Site 68 Sydney Olympic Park

Design Excellence Competition - Jury Report

June 2014

Garden Pockets

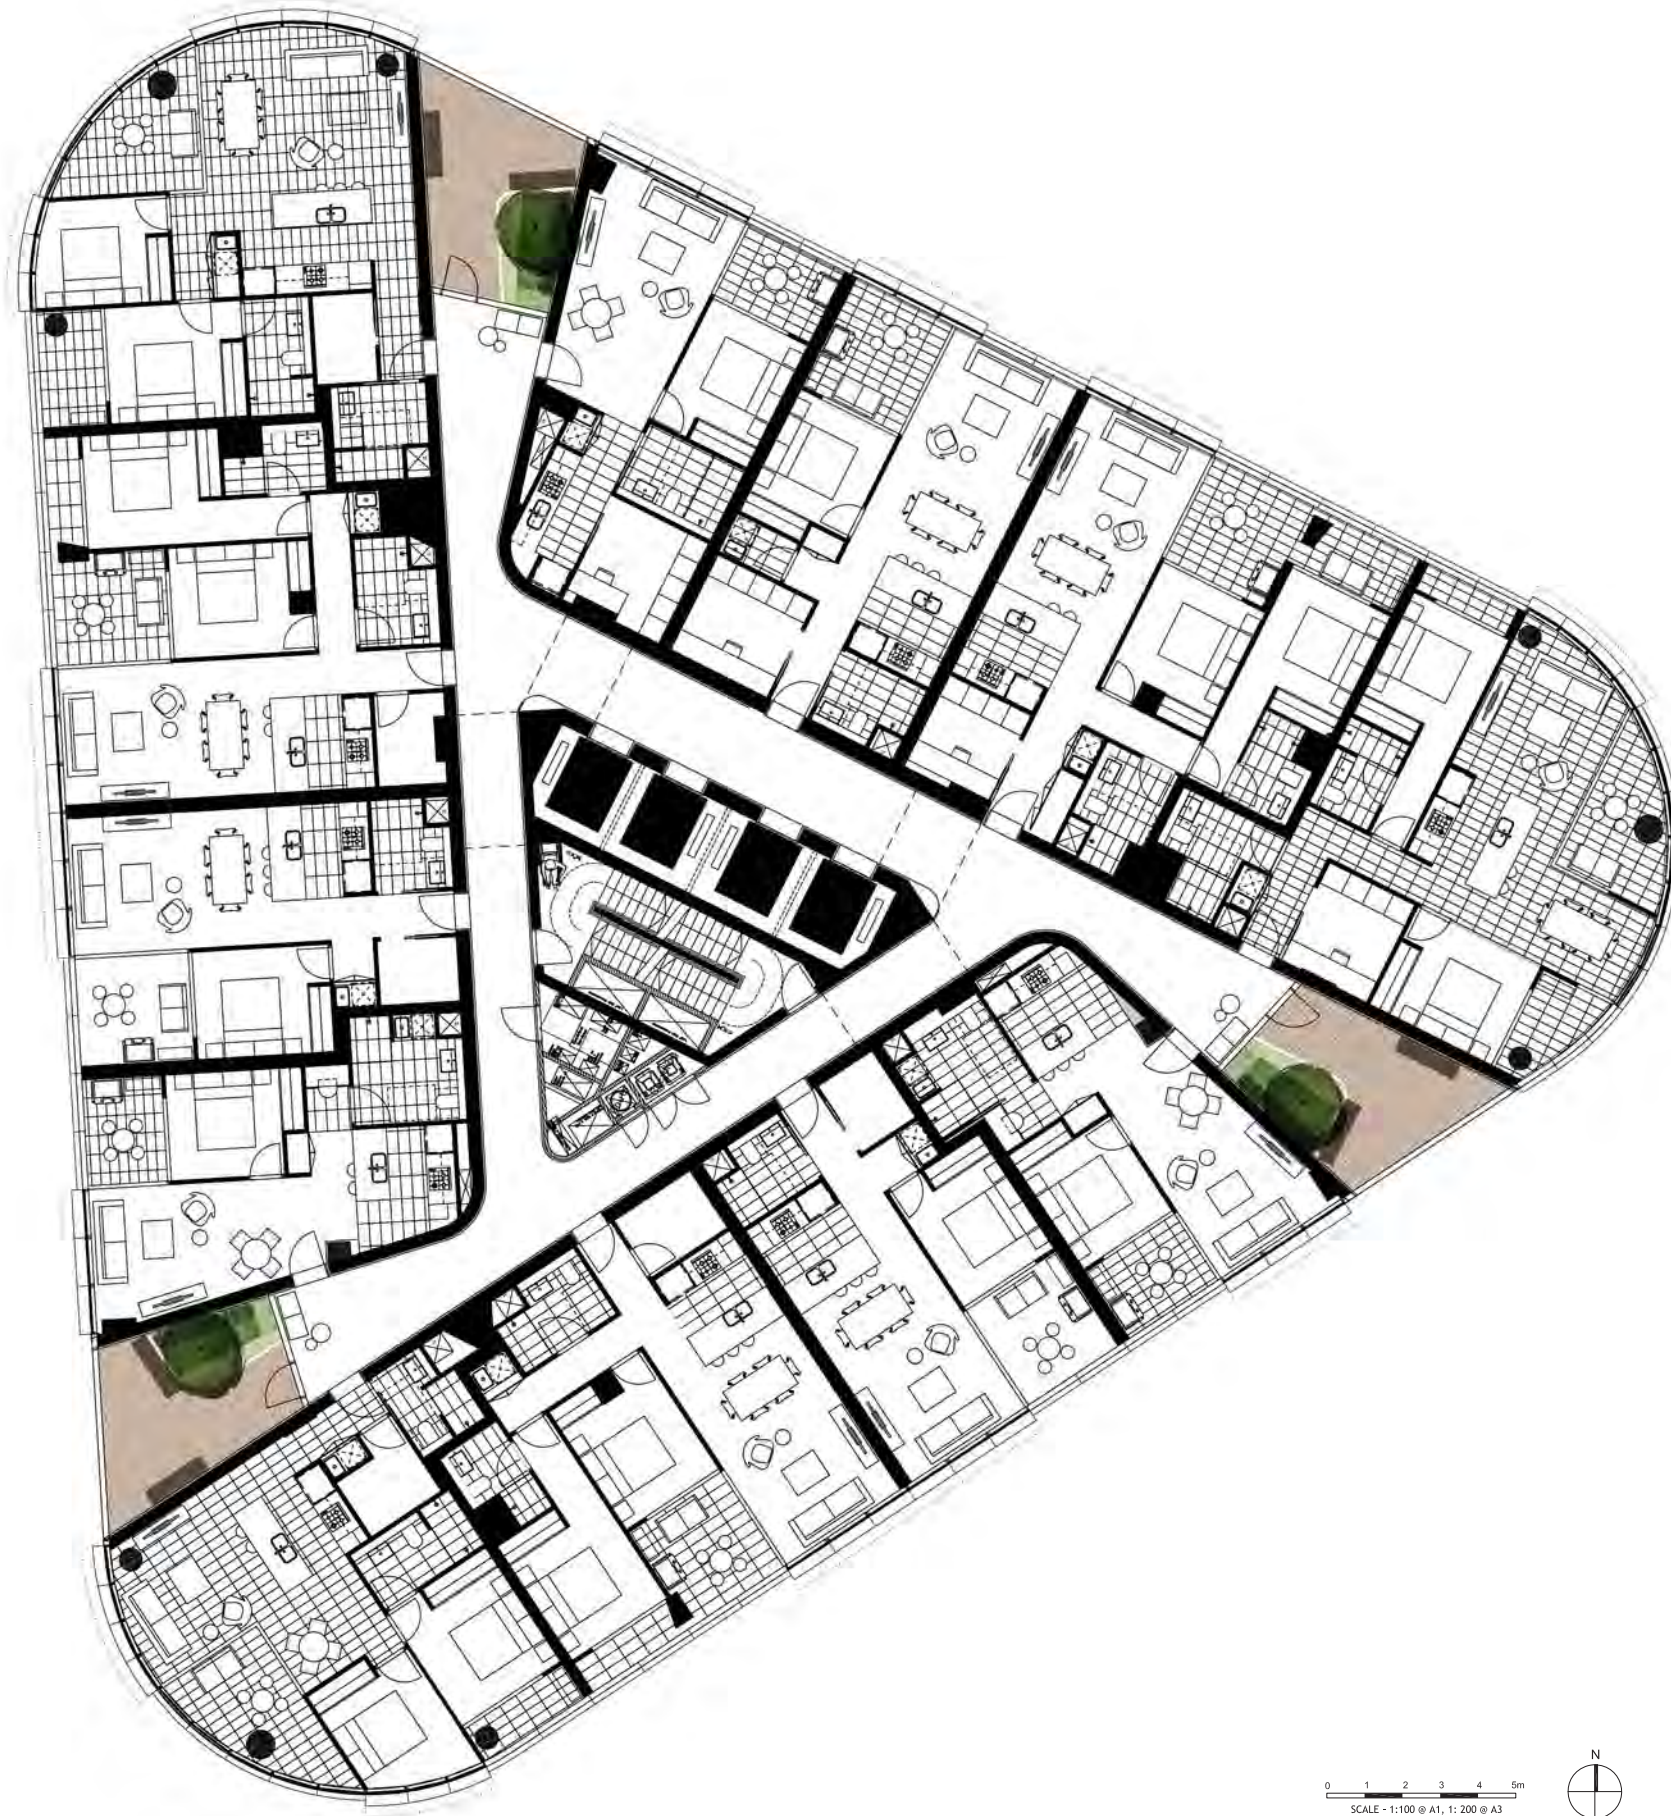
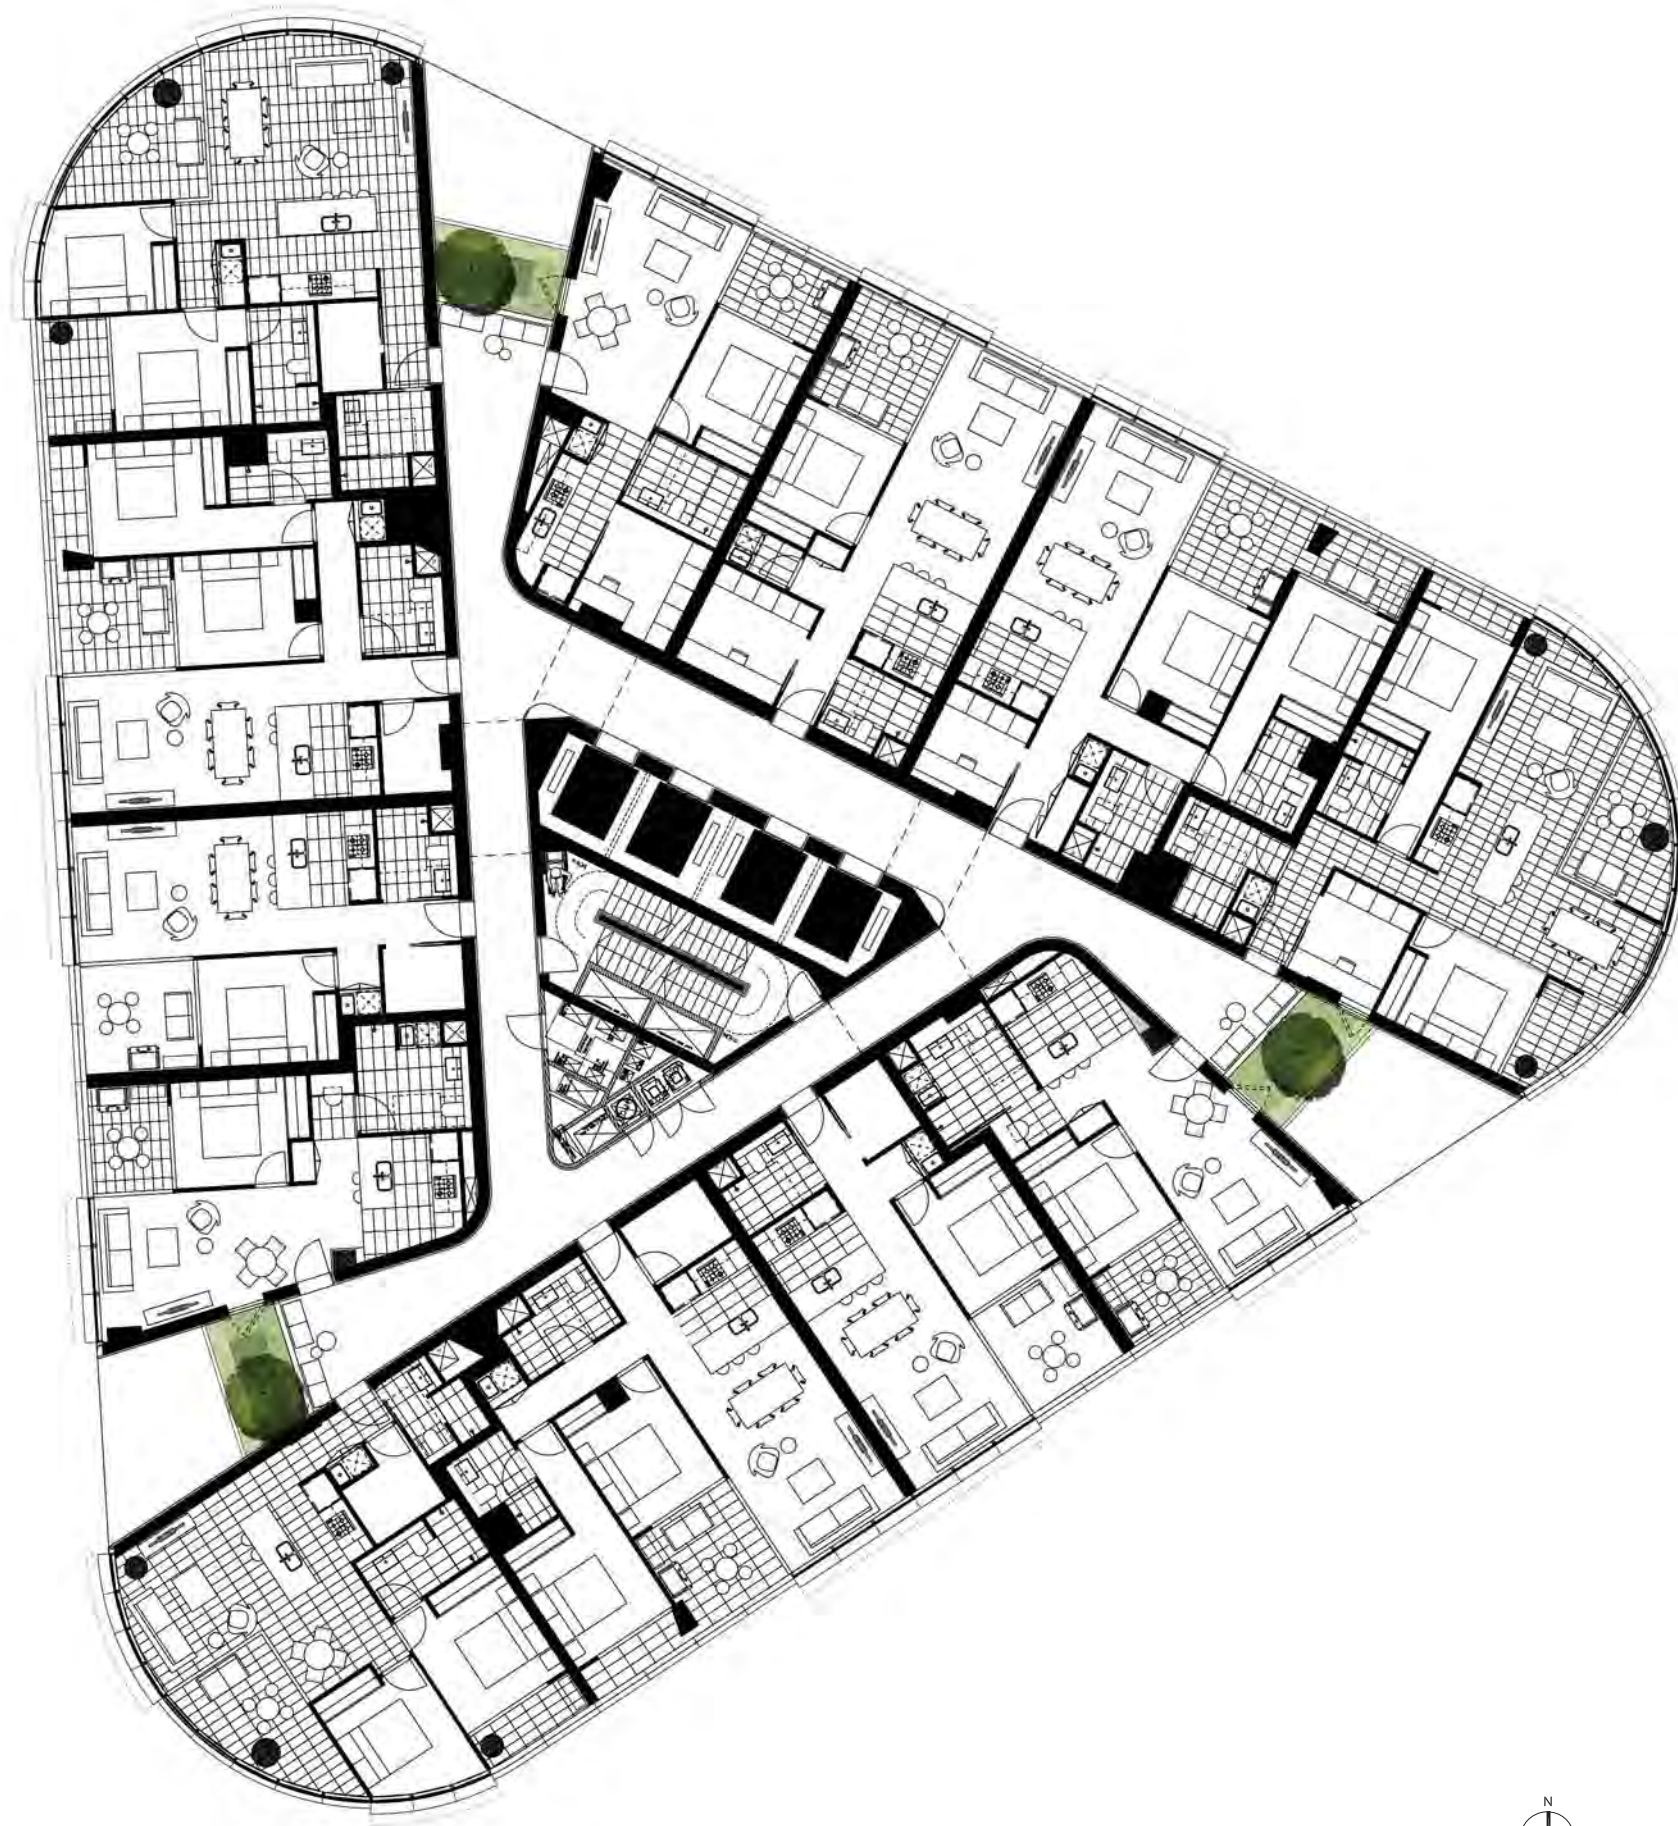
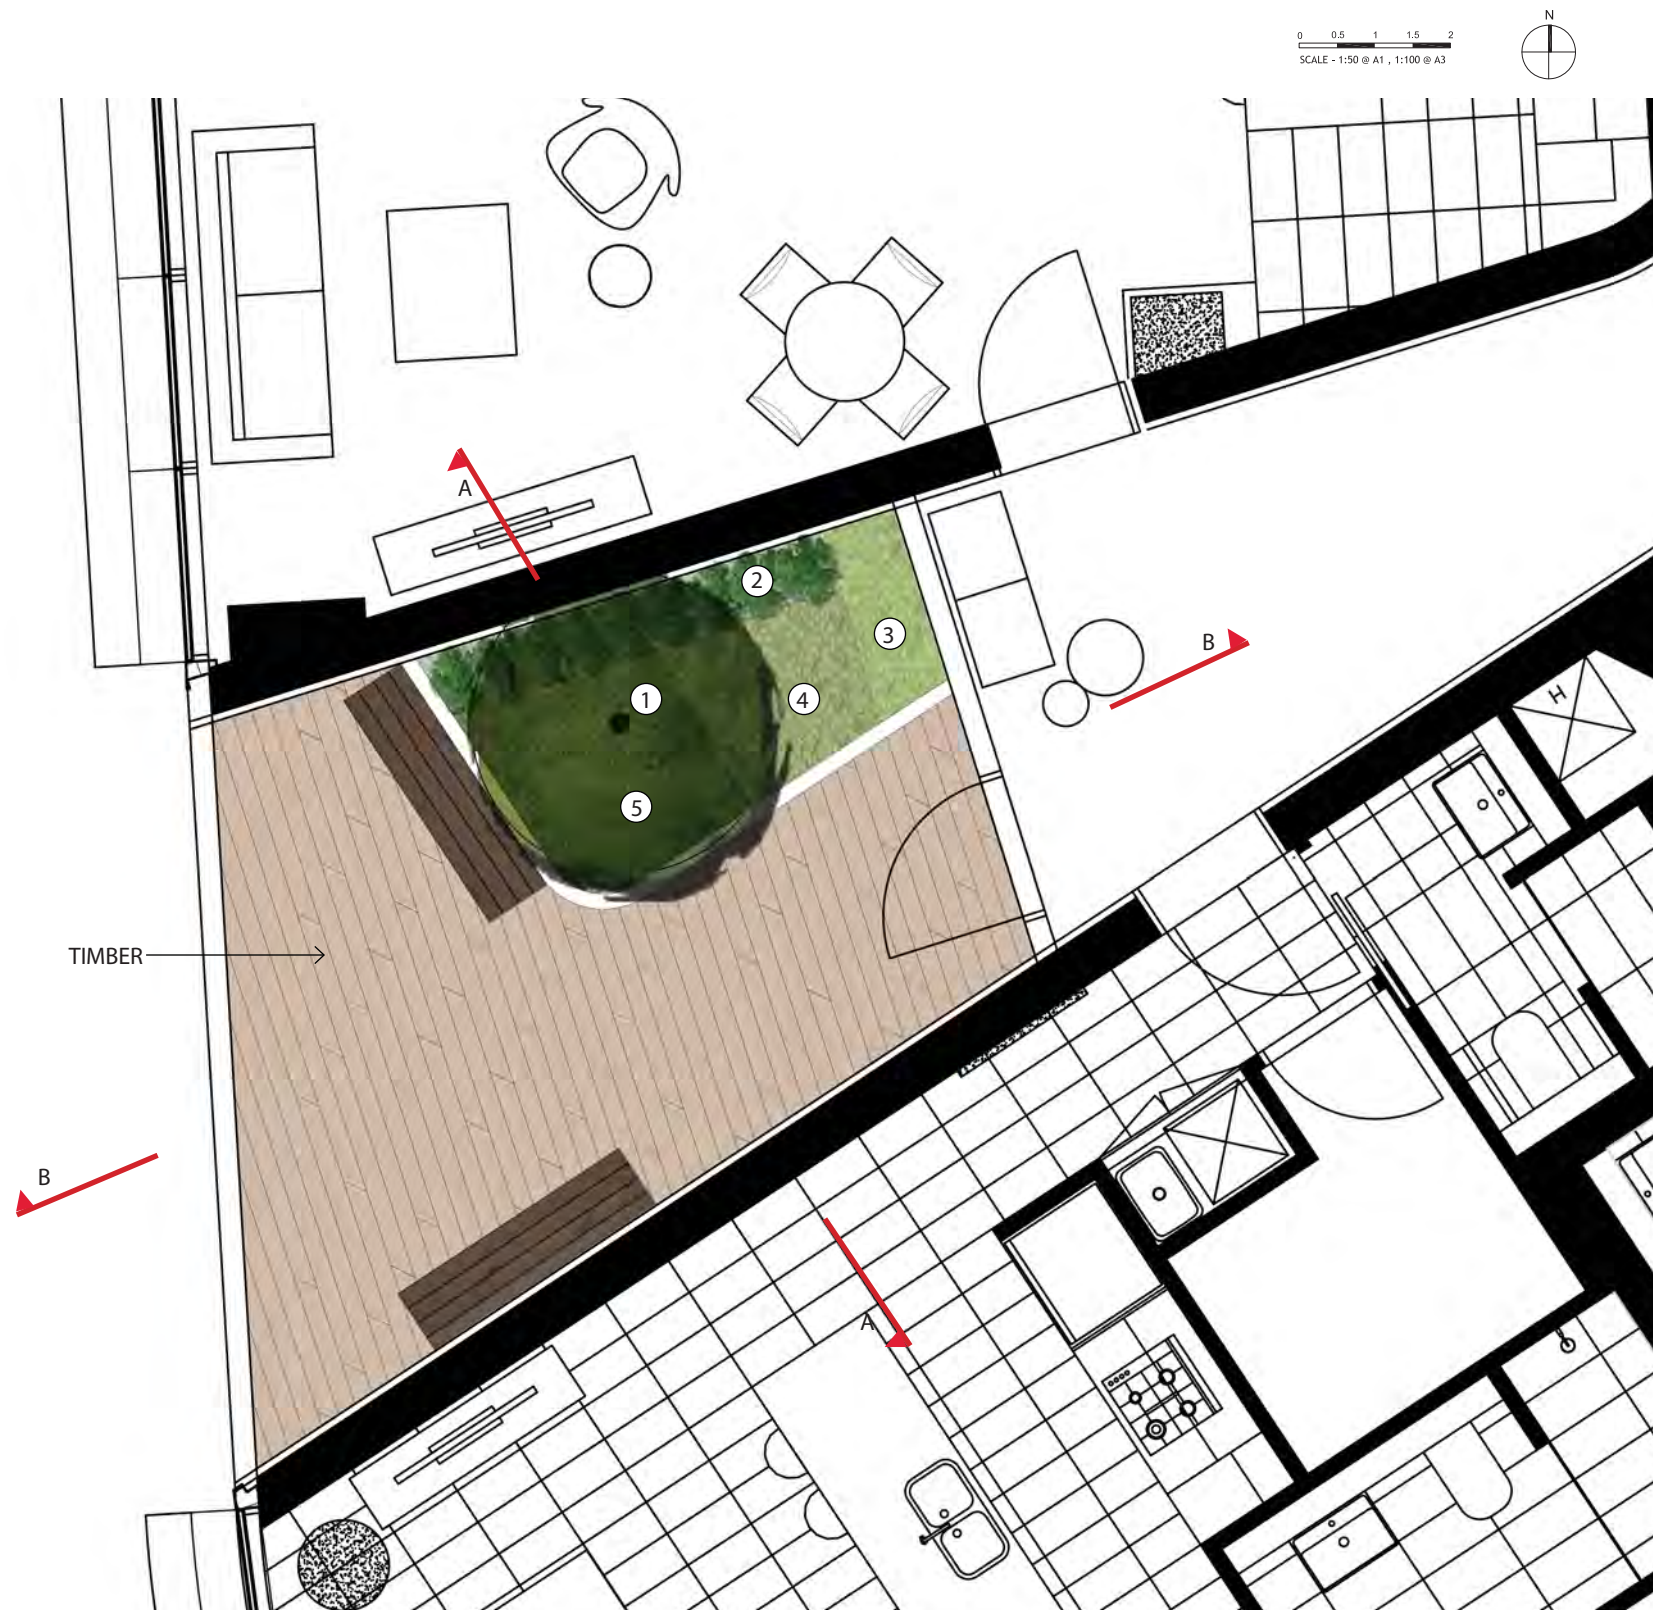
- The design of the vertical slots is to be developed to improve the shape and width of each slot in order to provide a greater level of amenity and usability to residents and visitors.
- The third 'privatised' vertical slot is to be made 'public' similar to the other two by redistributing 'lost' residential floor space to the top of the building.
